NEW PRIMARY SCHOOL IN EDMONDSON PARK – RESPONSE TO PUBLIC EXHIBITION COMMENTS

PROJECT NUMBER: 210104

PROJECT NAME: New Primary School in Edmondson Park

DATE: 12/08/2021

1 NORTH - EAST ELEVATION (BUCHAN AVENUE)
2000 1 : 250

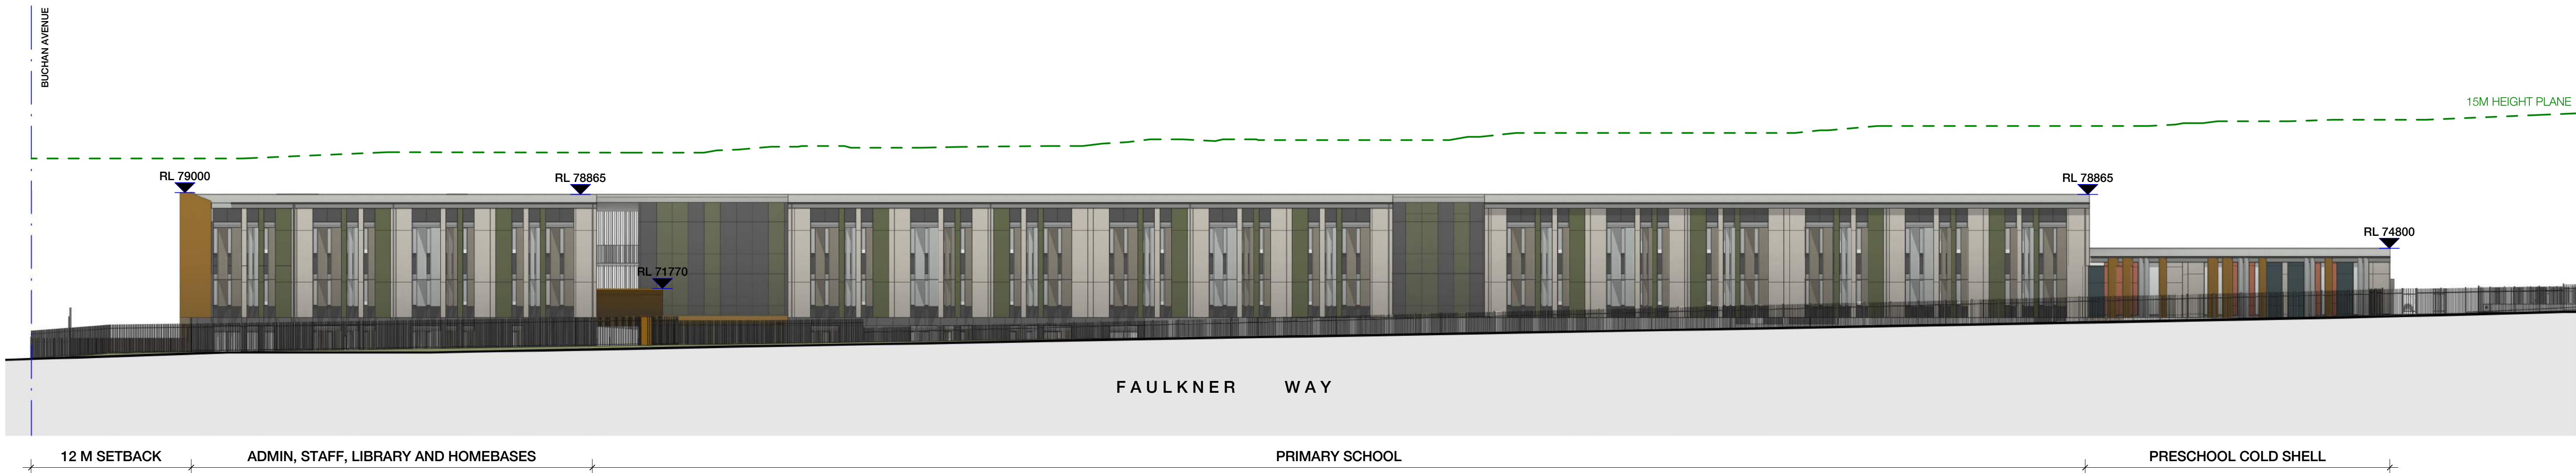
4. External glazing has been proposed facing Buchan Avenue and Faulkner Way to achieve internal noise levels, however a further review will still be required.

Detailed design (post SSDA approval) of the building facades shall continue in order to confirm that proposed façade elements and their areas will achieve a minimum sound insulation performance to comply with Educational Establishments and Child Care Facilities SEPP requirements.
